RWE Renewables UK Solar and Storage Limited

Planning Act 2008 – Response to advice following issue of decision to accept the application for examination (Section 51 Advice)

Application reference: EN010139

On 8 March 2024, the Planning Inspectorate (PINS) issued a decision by the Secretary of State (SoS) to accept an application made by RWE Renewables UK Solar and Storage Limited (Registered Company No: 14539260) (the Applicant) for an Order Granting Development Consent for the Byers Gill Solar project (the Proposed Development).

Sheet 7 of 13

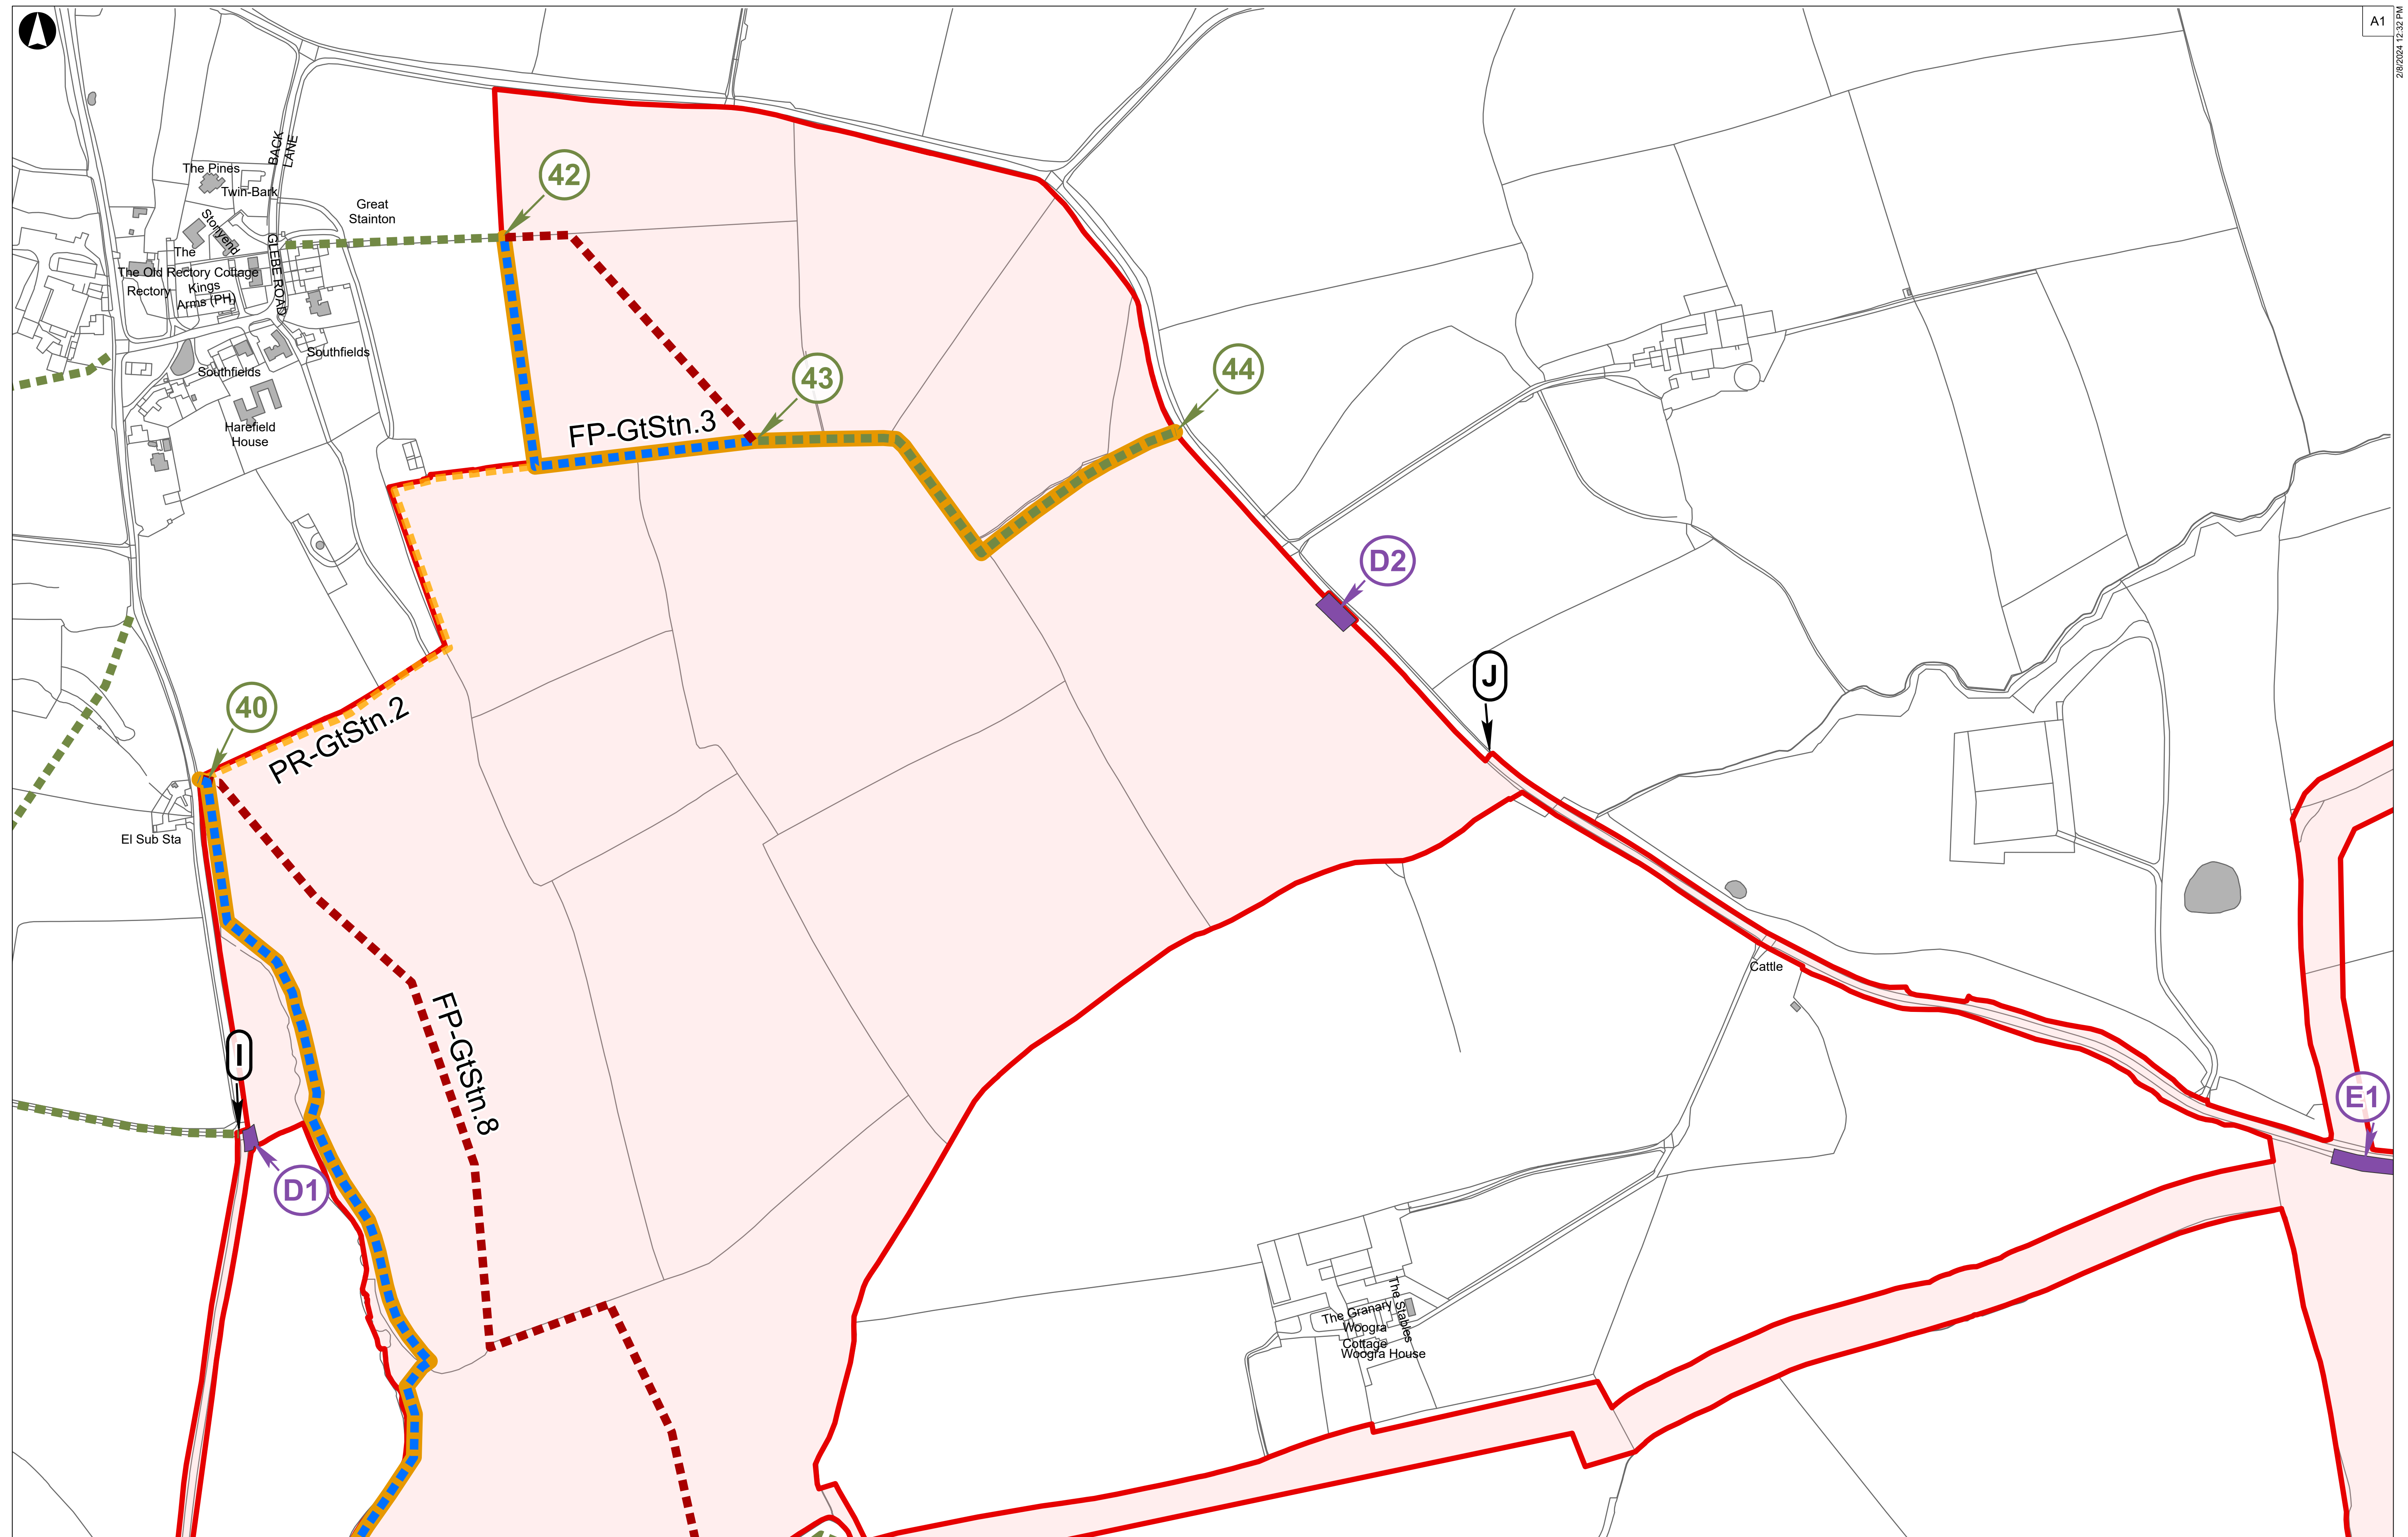
<p>Works Plans (Doc 2.2)</p> <p>The draft Development Consent Order refers to "Works No. 5" under Schedule 1 as works connecting Work No. 4 to Work No. 6. Upon</p>	<p>The 132kV cable which will connect the onsite substation (Work No.4) to the Norton substation (Work No.6) has been included in both Work No.3 and Work No.5, in different</p>

Advice	Applicant Response
<p>review of Works Plans Sheet 7 of 13 it doesn't appear that Works No. 5 connects directly to Work No. 4, but instead Work No. 3. The Applicant may wish to review these plans and ensure consistency with the draft Development Consent Order. Schedule 3 of the draft Development Consent Order uses "street", "highway" and "width of highway" interchangeably. "Street" and "highway" are defined differently in Article 2. The Applicant should review the drafting and amend/clarify as appropriate. In relation to the proposed alternative on-road cable route, for some plots (for example but not limited to 2/6, 3/6, 7/6) part of the subsoil up to half width of public highways is in private ownership. The Applicant should review these when carrying out its review of Schedule 3 to ascertain whether the powers sought in Article 9 are sufficient as currently drafted or whether the Applicant will need CA of the relevant sub-soil or any other additional rights not secured at the moment. The Applicant's reasoning should also clearly be set out in the in the relevant application documents including the Statement of Reasons (Doc 4.1).</p>	<p>portions. The cable is within Work No.3 where it is <u>within panel areas</u> (see ES 2.3.4) and then within Work No.5 where it is outside of those panel areas (see ES 2.3.6). It is hoped that with this explanation the approach that the Applicant has taken to the identification of these works on the Works Plans (Document Reference 2.2) is readily apparent.</p> <p>In the Applicant's view the use of the terms "street", "highway" and "width of highway" are used consistently within the dDCO, taking account of the way in which "street" and "highway" have been defined in Article 2. Schedule 3 (and Article 9) follows the accepted form of the drafting of these provisions, as explained in the Explanatory Memorandum (Doc 3.2). The Applicant would therefore respectfully suggest that drafting changes are not required, but is open to engaging on these matters with the appointed Examining Authority at any early DCO hearing which may be called.</p> <p>As far as the on-road cable route is concerned, the Applicant is satisfied that the existing drafting of the dDCO and approach which has taken to CA is appropriate. This is explained further in the following row of this table.</p>
